RE: 79 Deerfield Road, Portland, Maine  
Structural Issues, Damage at Rear Porch Framing

This report is in response to my site visit on June 9, 2017. It presents my findings and recommendations based on my observations and office computations.

ELEVATION - BACK PORCH
N.T.S.

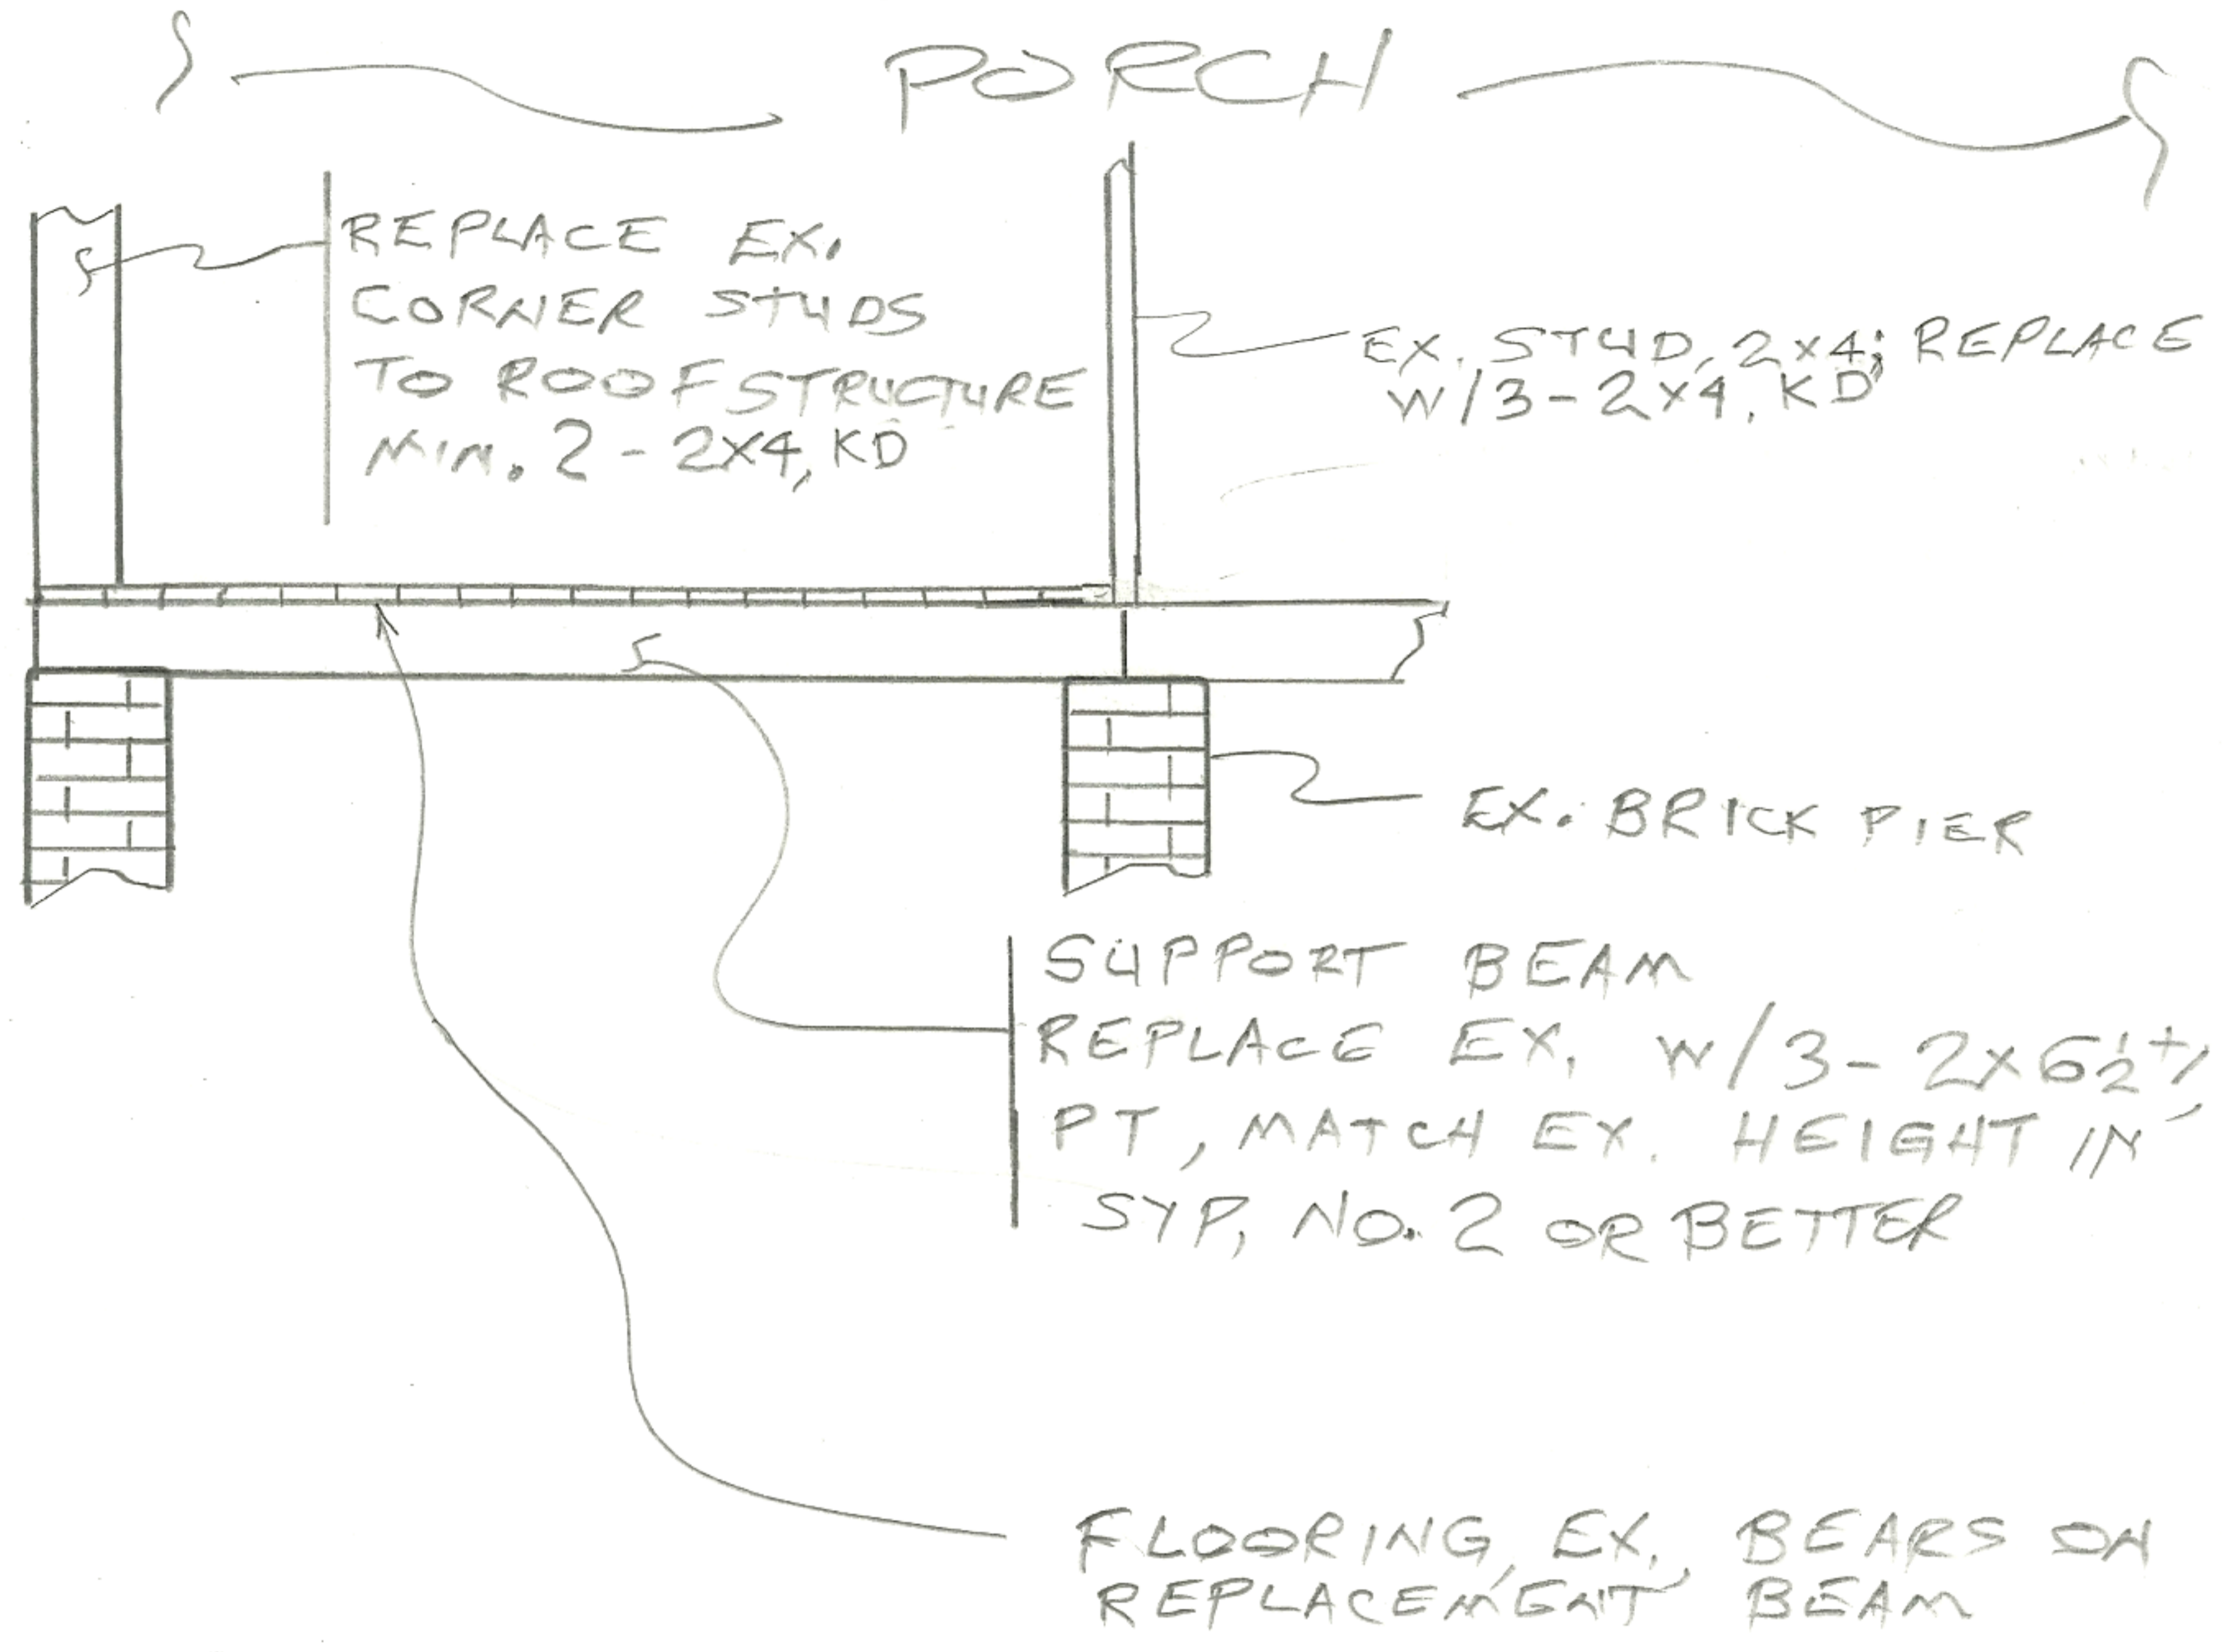
1. The lower third of the corner post at the northeast porch corner was heavily damaged, apparently by insects.
2. The perimeter beam that supports the porch floor was likewise damaged in the area adjacent to and extending westerly from the northeast corner post.
3. Some significant cross-grain crushing of the perimeter beams at the butt joint was observed below a bearing stud over the easternmost interior brick pier.
4. Brick foundation piers were in satisfactory condition and provide adequate support for the posts and beams described above.

1. The corner post size is adequate for the loading. It should be replaced with new pressure treated (PT) lumber, sized not less than the existing members.

2. The perimeter beam, approximately 4" X 6" was "sistered" at some time with an additional 2" X 6" member. The resultant size, i.e. a triple 2" X 6" built up member is adequate for the imposed loading. The damaged members should be replaced with a triple 2" beam, in height matching the original 4" X 6". The resulting member will be 4 ½ wide. The replacement lumber should be PT Southern Yellow Pine, No. 2 or better.

3. Corrosion resistant fasteners, e.g. nails, compatible with PT limber must be used.
4. To relieve the crushing of the butt joint, a bearing plate of steel, minimum 3" wide X 4 ½ " long X 3/16" thick should be used at the stud noted above.
